Recommendation Report for Planning Permission for Works or Extension to a Dwelling

REF NO: FP/73/20/HH

LOCATION: 8 Myrtle Copse
Felpham
PO22 8FQ

PROPOSAL: Conversion of garage and conversion of garage roof space to habitable use to form a proposed annex.

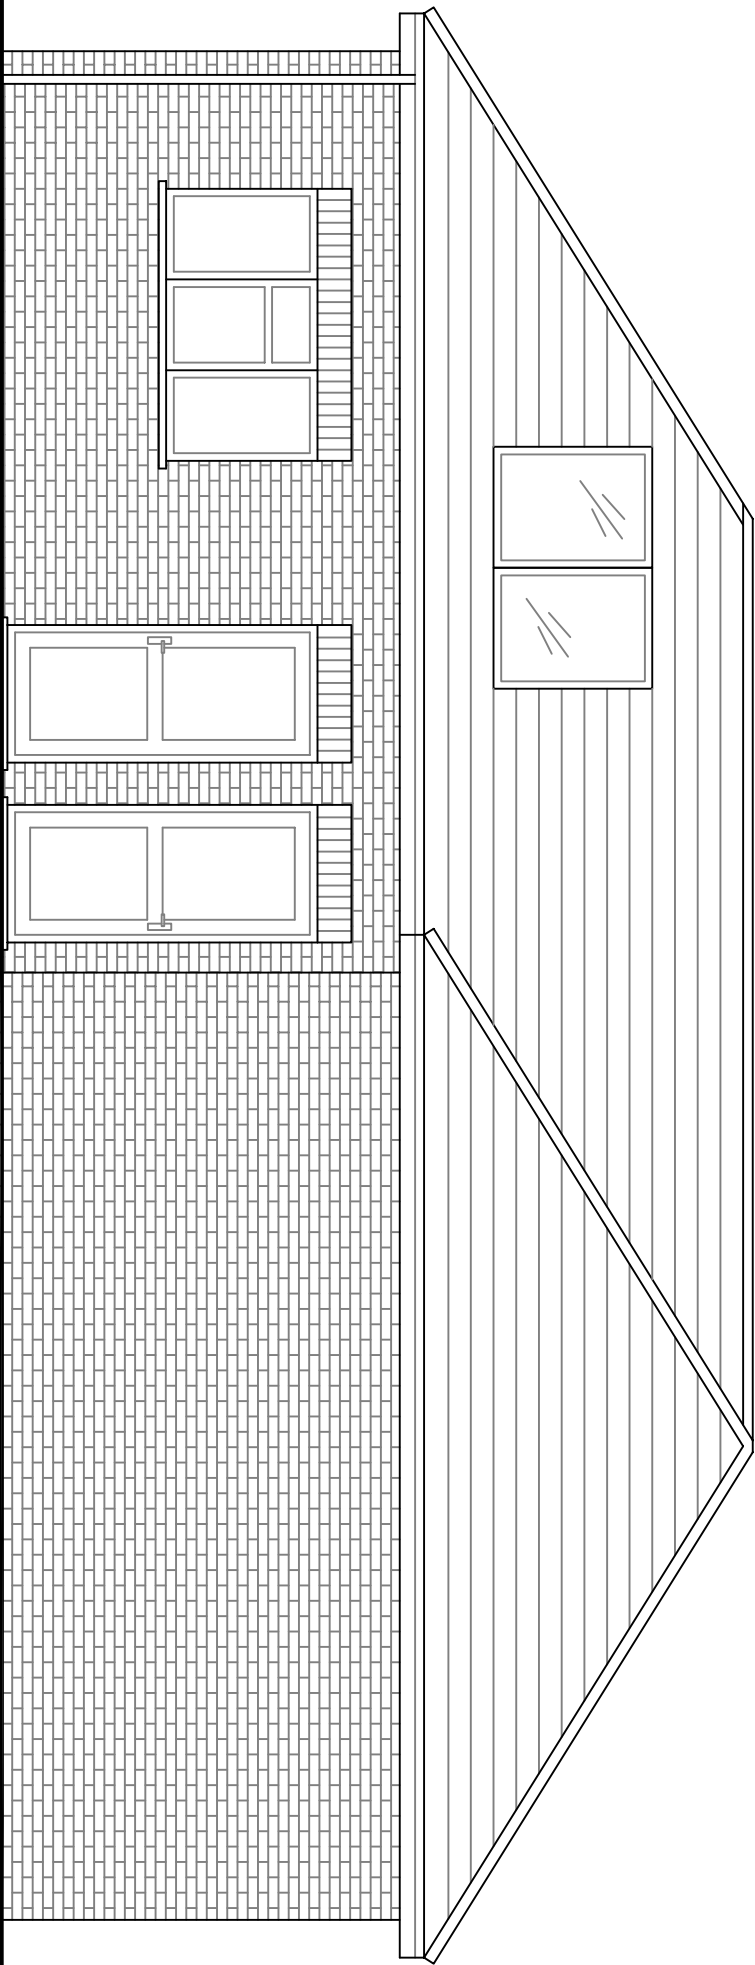
Due to the siting of the extension to the rear, the addition is not considered to give rise to adverse overbearing or overshadowing impacts upon neighbouring amenity with garages located to the rear of the site. There are to be two velux rooflights in the building and due to the angle of the garage the overlooking would generally be towards the host dwelling. There may be some oblique views towards the neighbour but due to their size, position and angle of the roof any overlooking should not result in demonstrable harm to the neighbour.

Proposed West Elevation

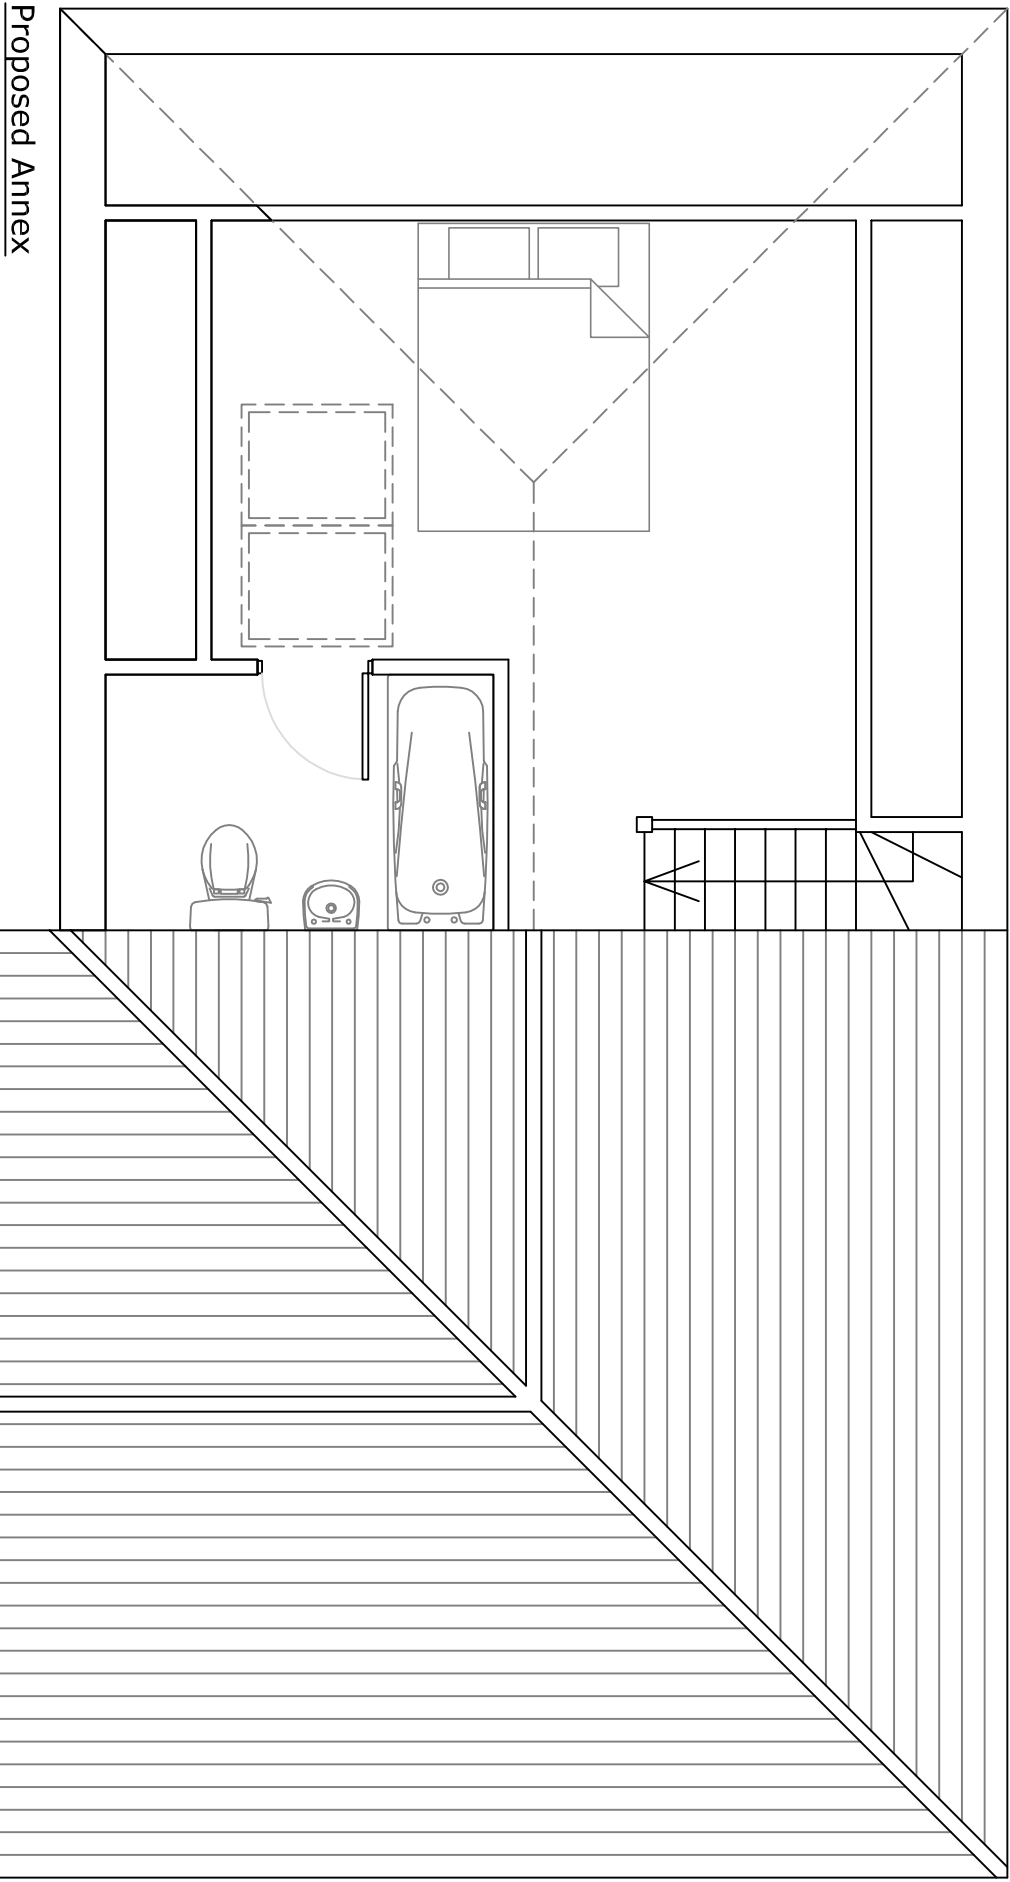
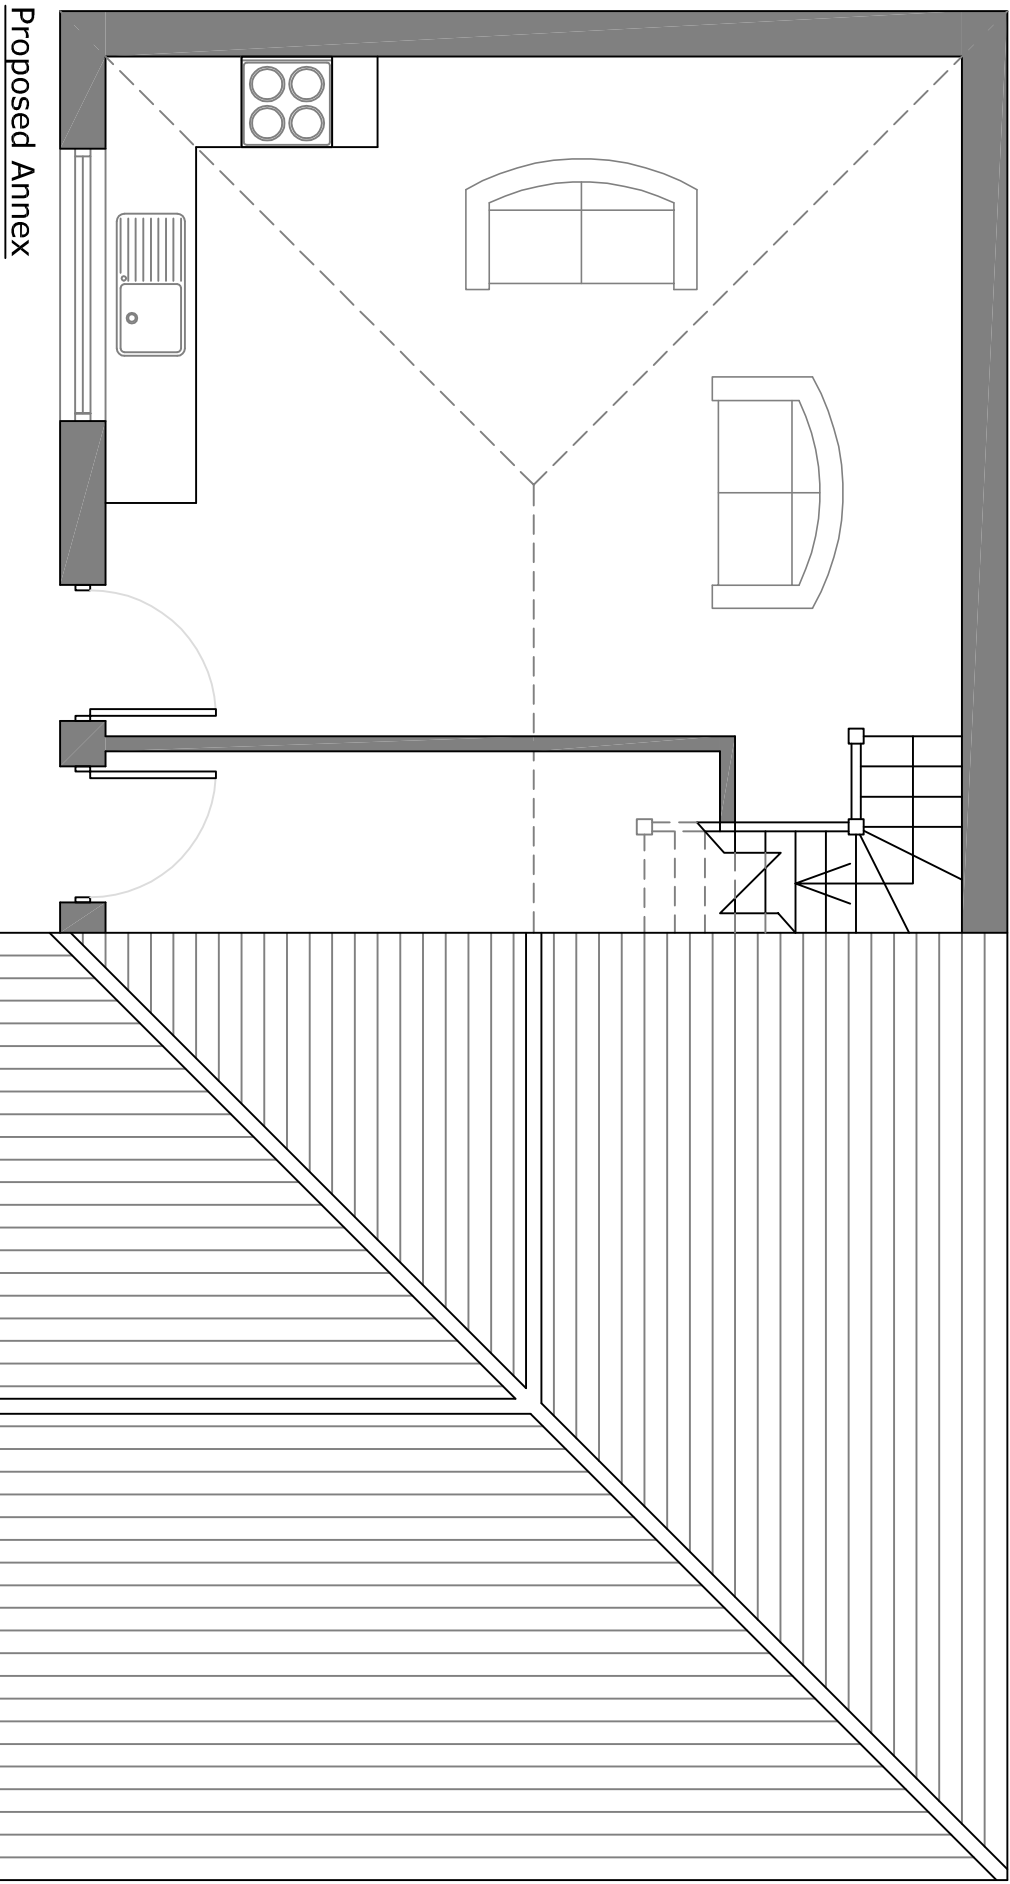
The change to the front elevation is modest and with surrounding properties of a varied style and design the alteration is not considered to adversely impact the appearance of the garage. It is considered that the proposed development will not have an unacceptably adverse impact upon the established character of the area and will accord with D DM4 and D DM1 of the Arun Local Plan.

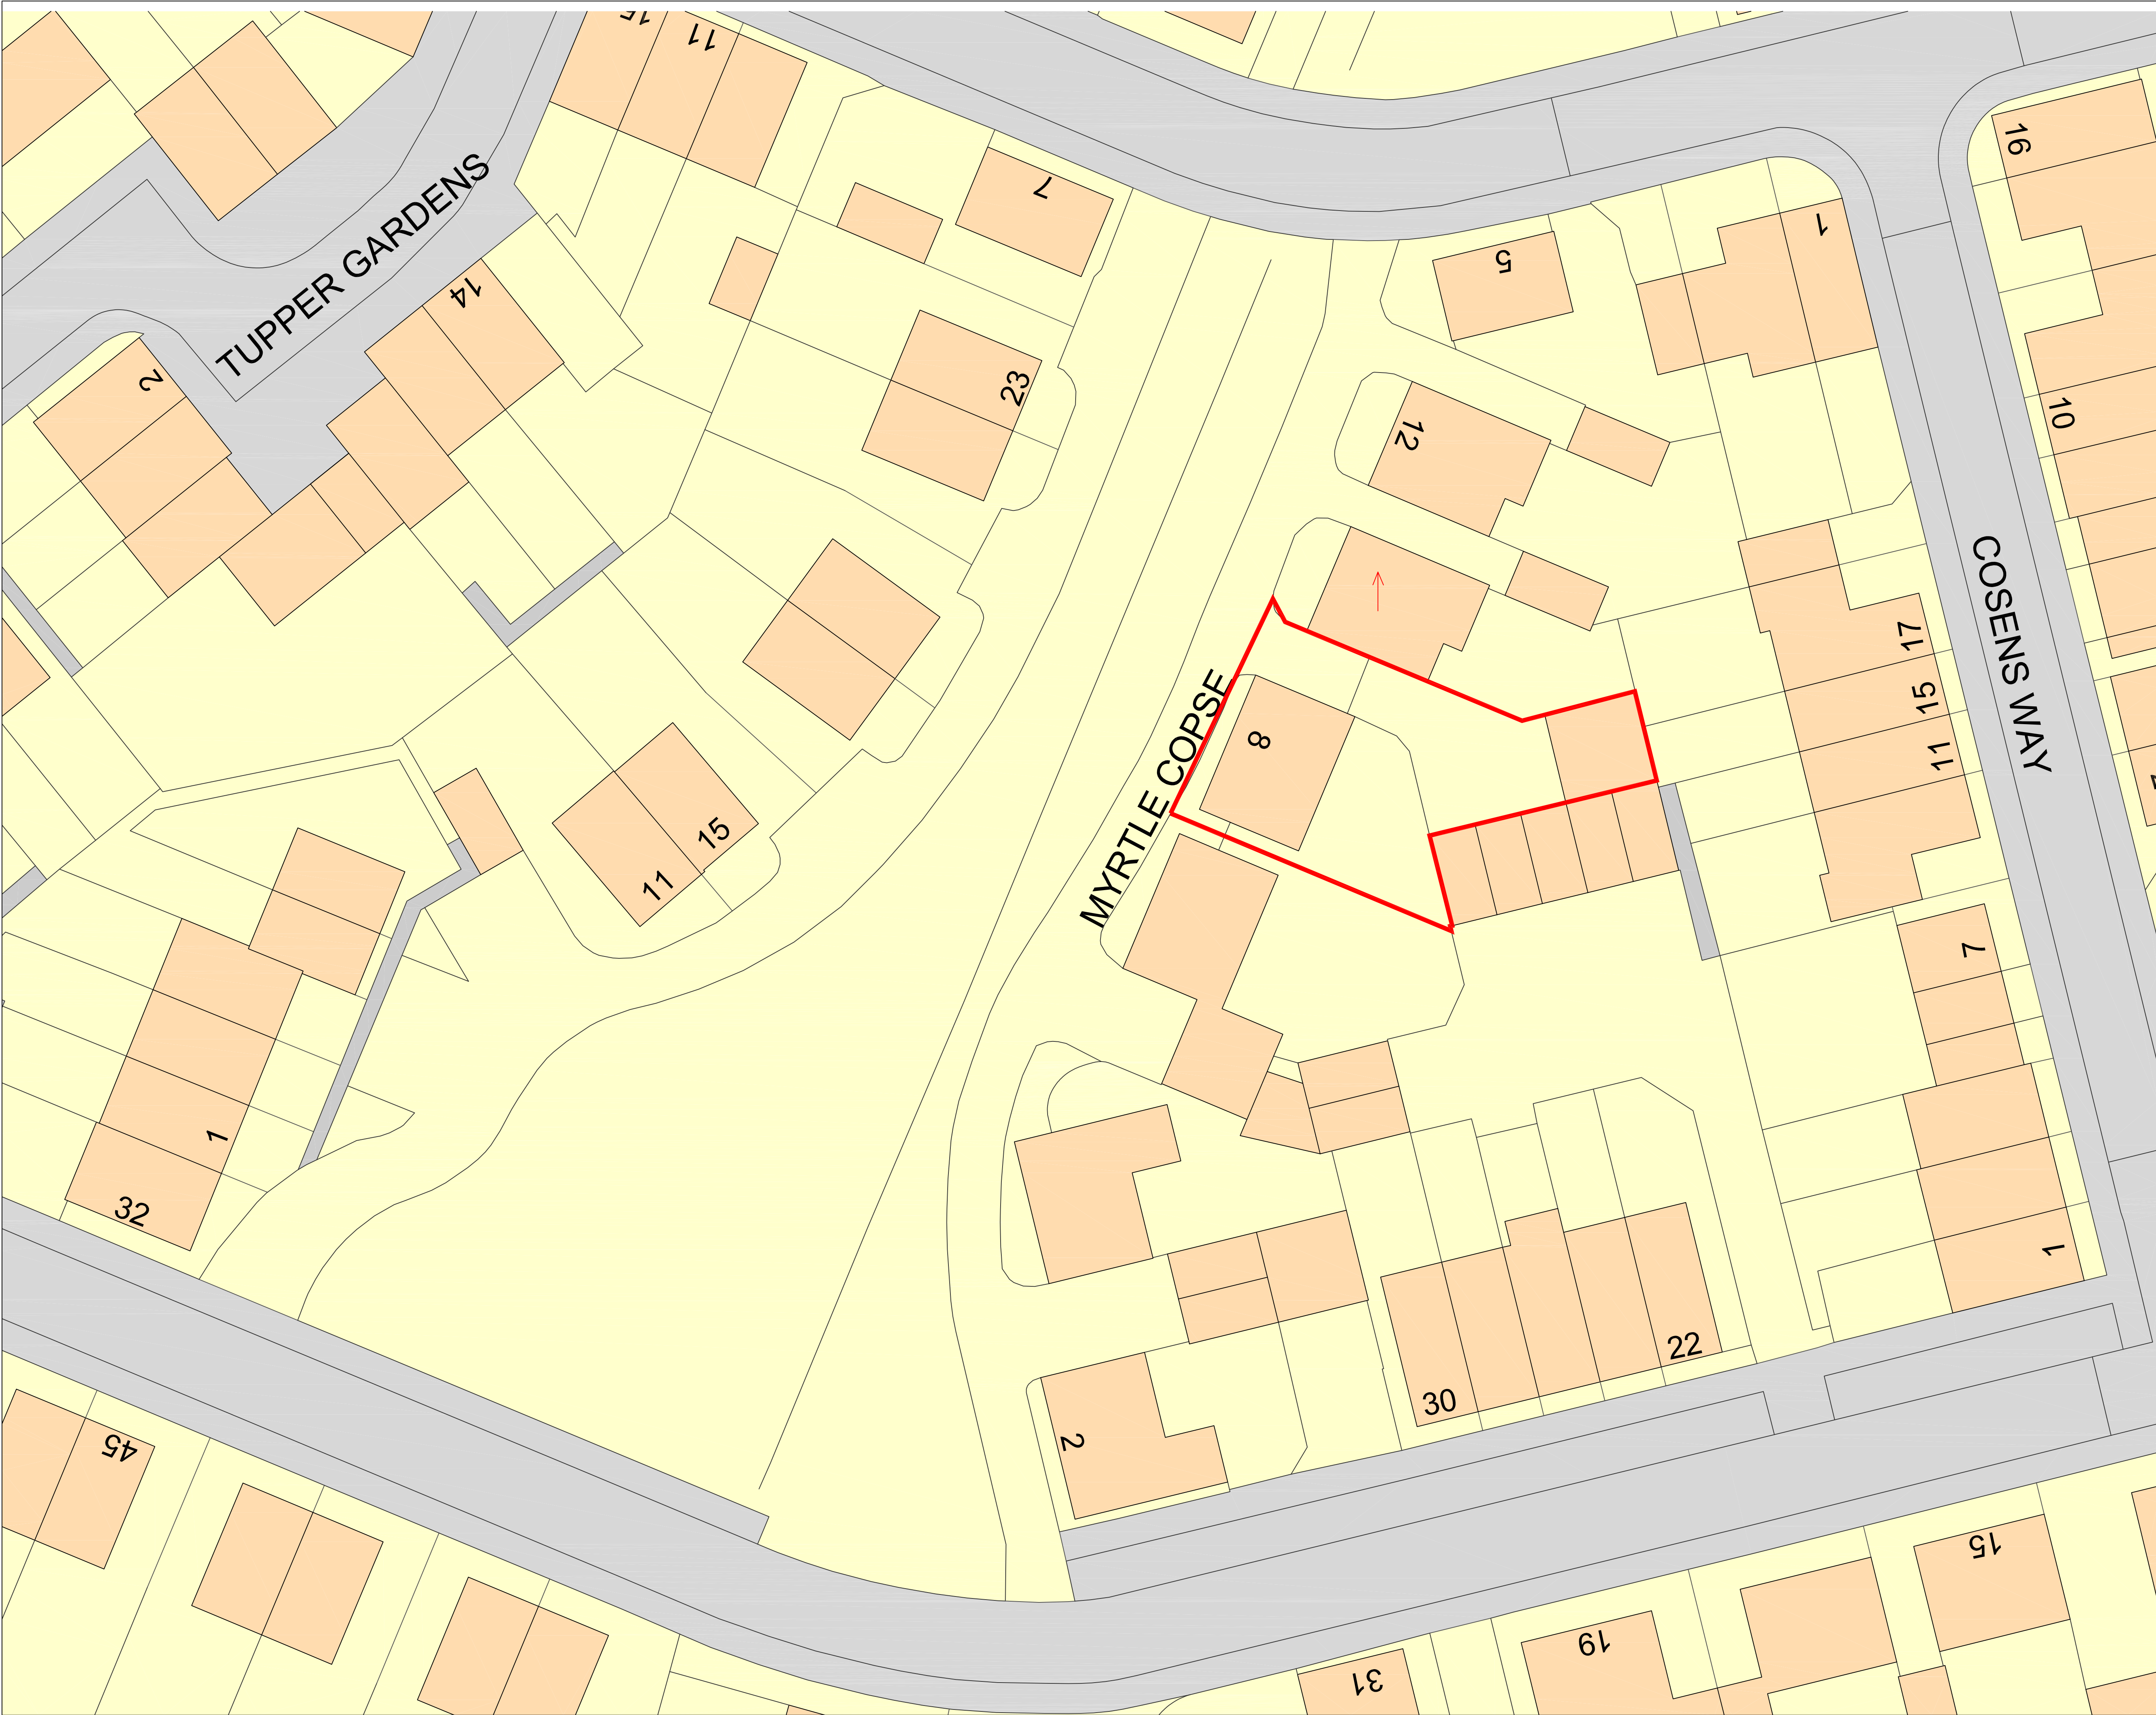
The conversion will result in the loss of a garage however with sufficient space for parking available (6 spaces) to the front of the dwelling and on the driveway, the conversion is not considered to impact upon parking or highway issues.
